SANDSTONE PRECINCT

DESIGN REVIEW PANEL - ADVICE 10

4 October 2019

EDUCATION BUILDING

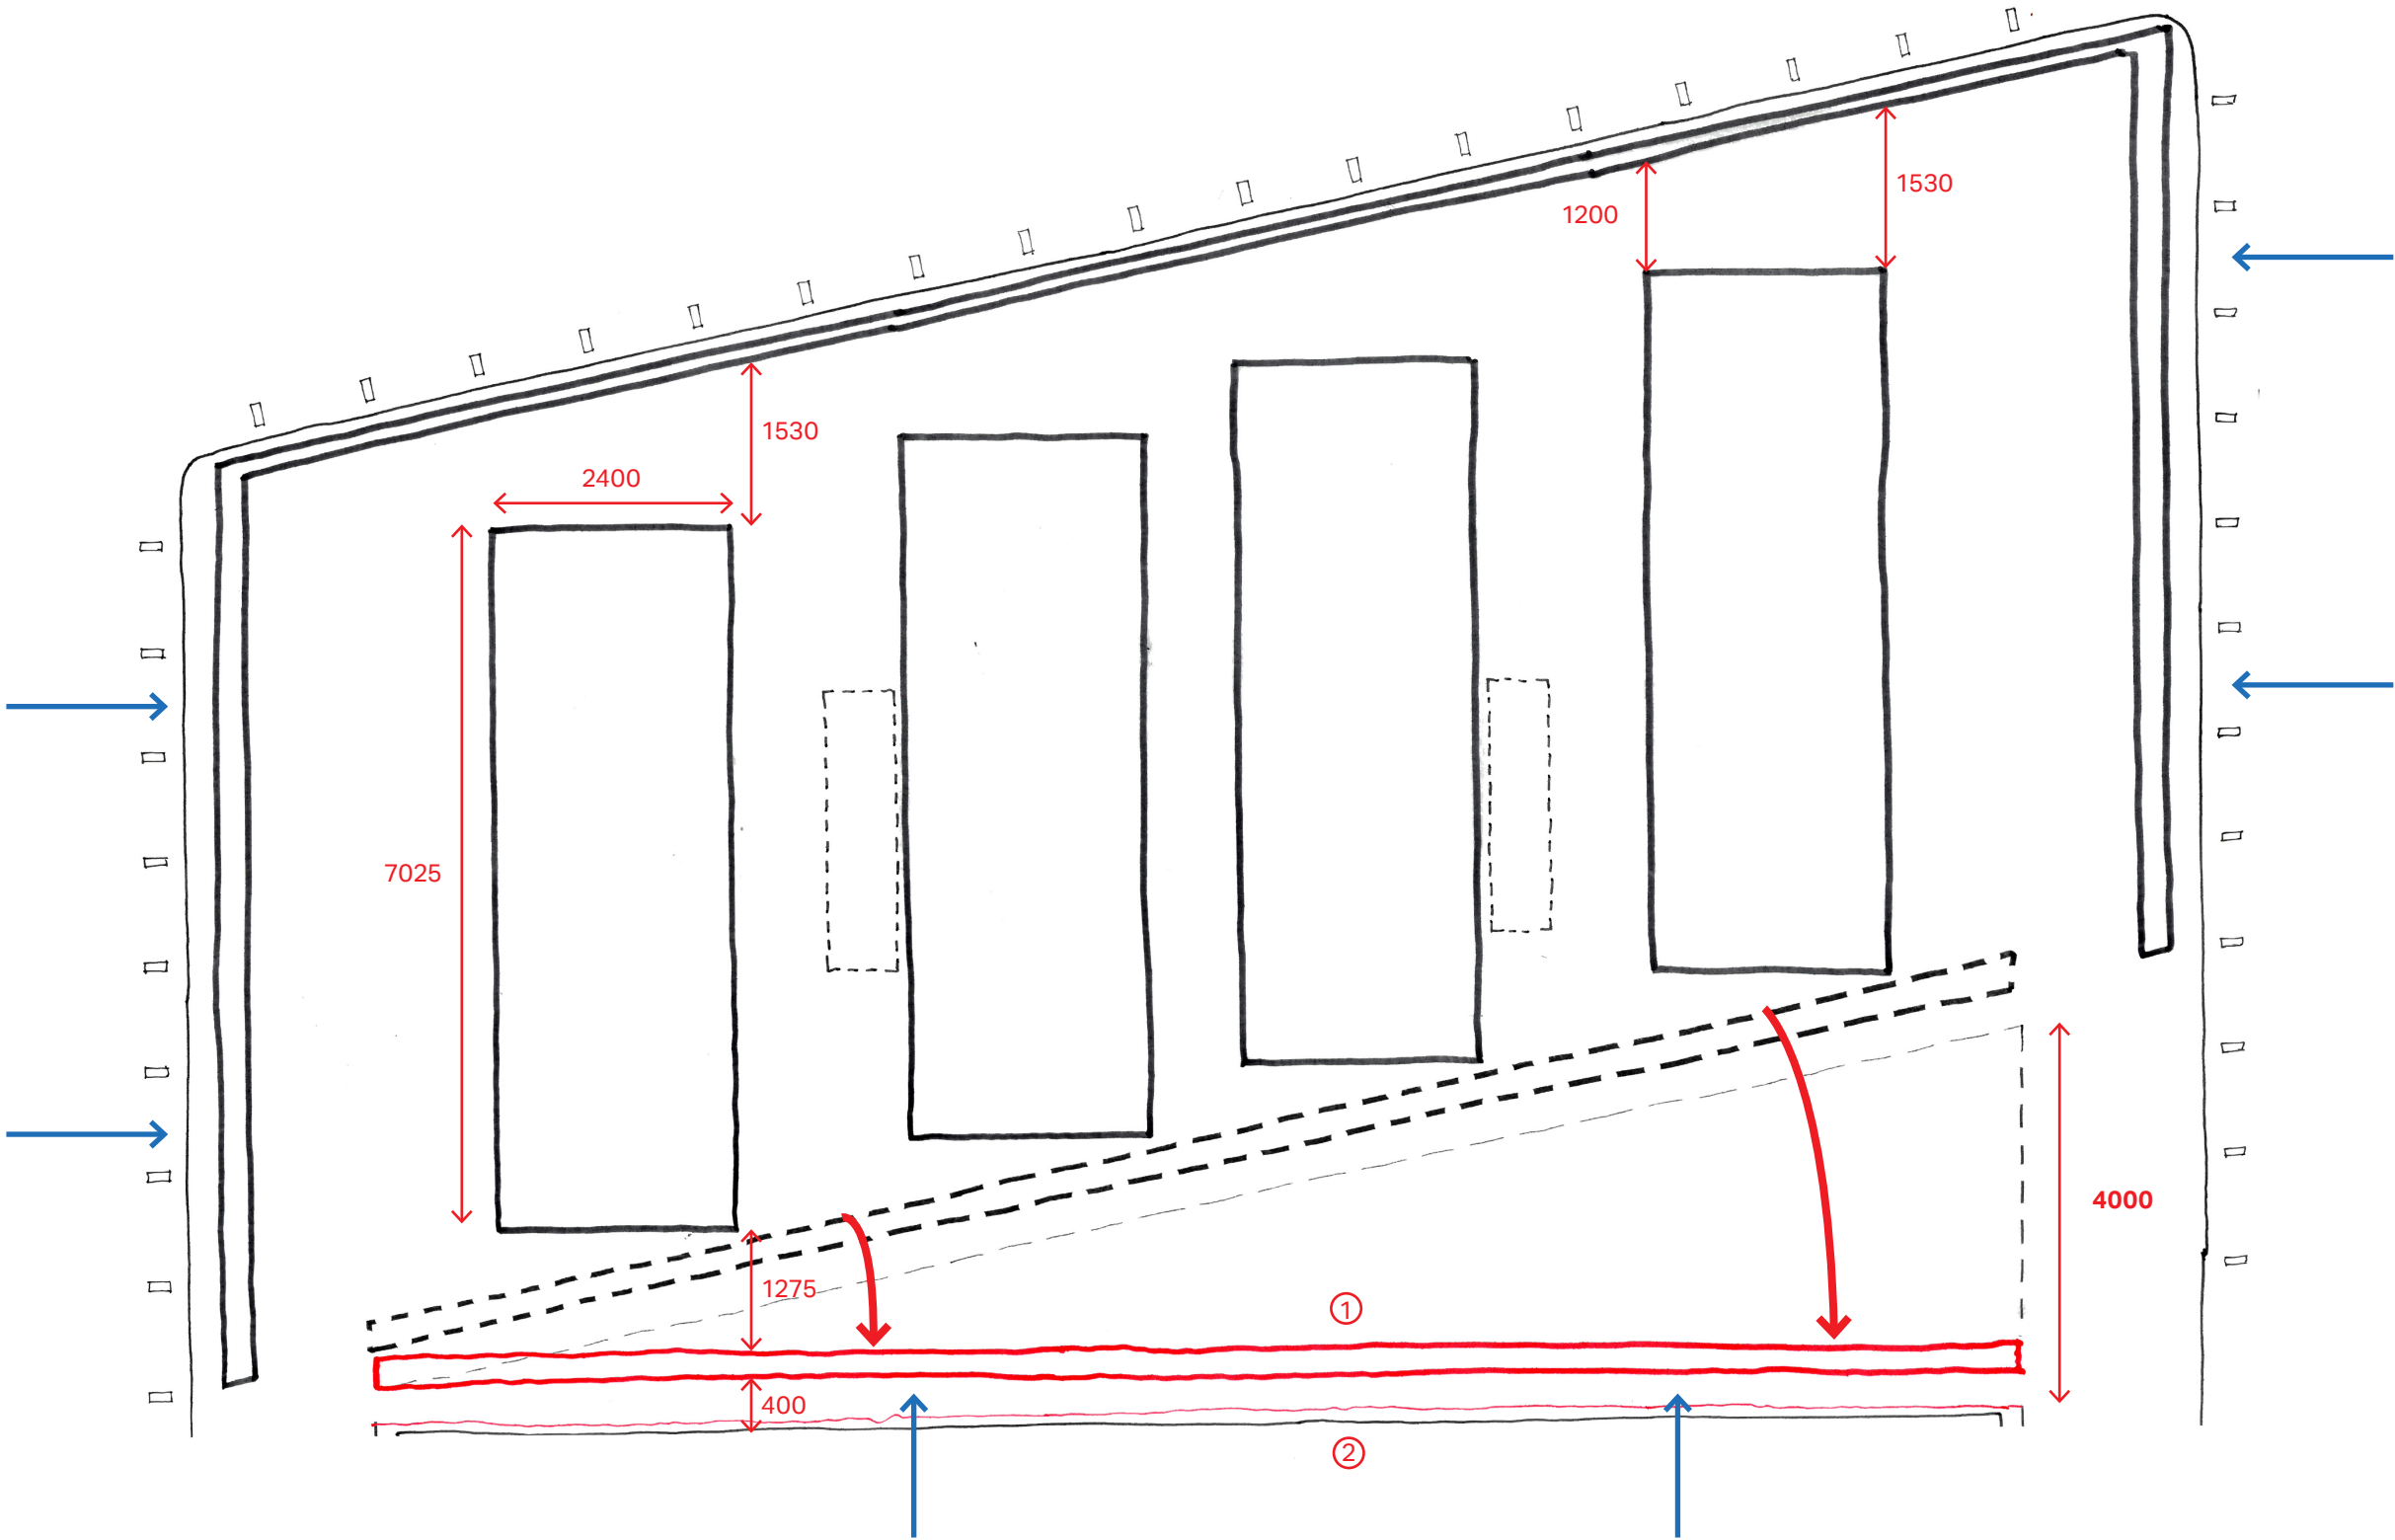
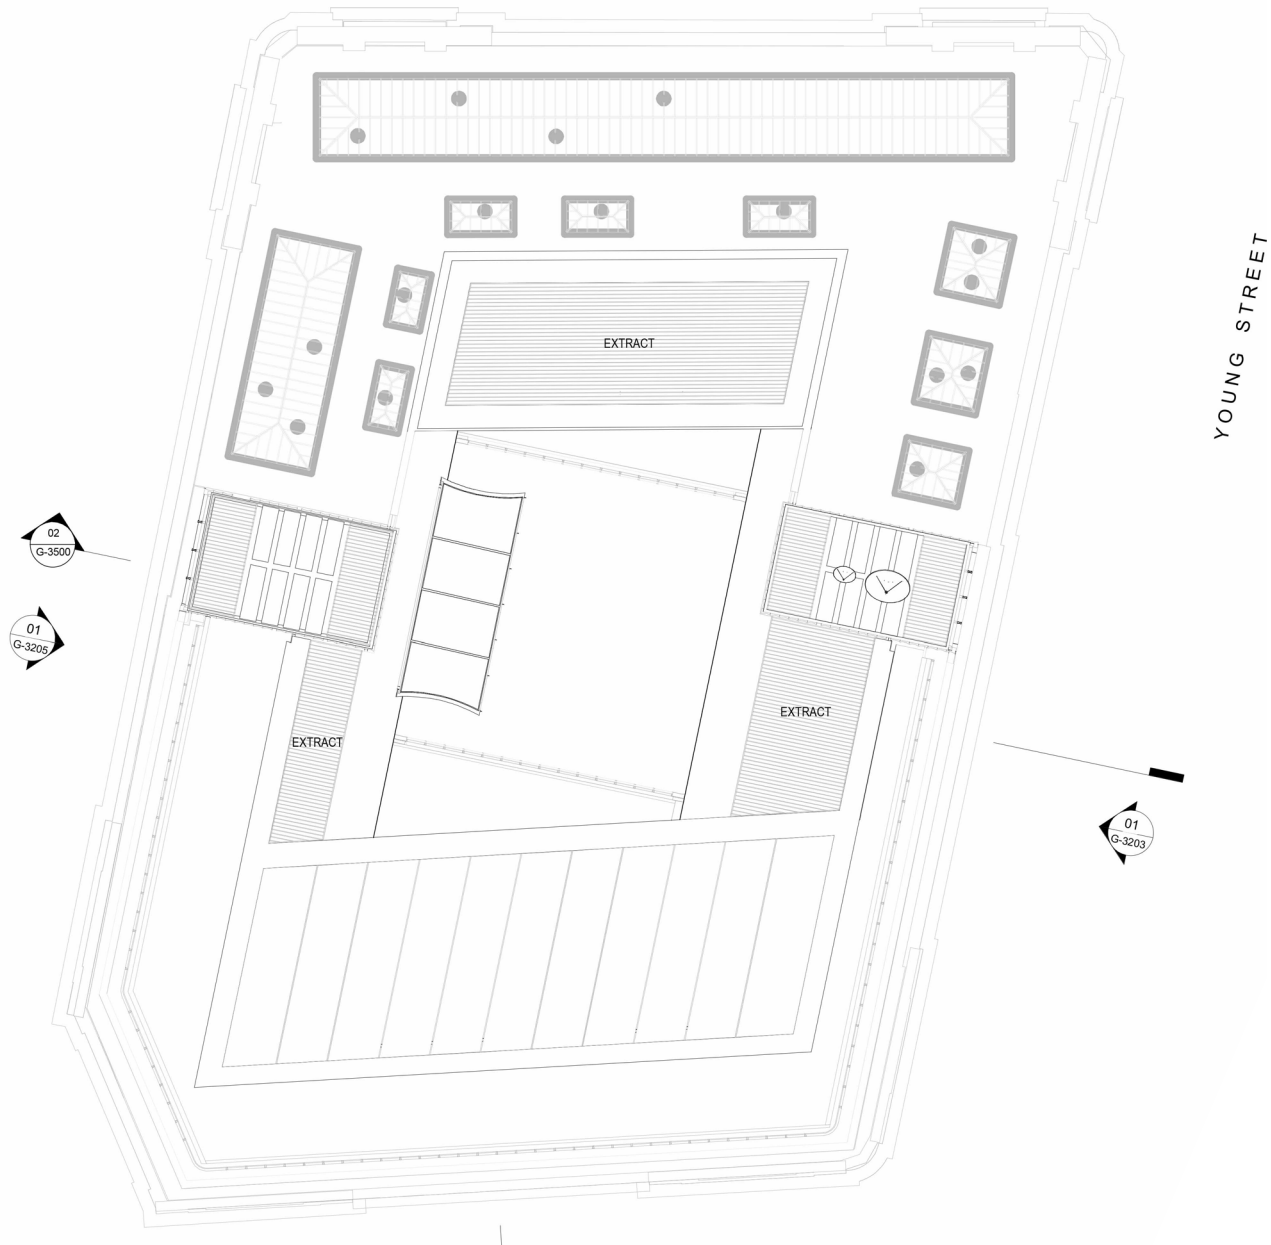
The Panel notes the change in size of the cooling towers and that the external envelope to the surrounding walls will not change except where it faces the internal courtyard.
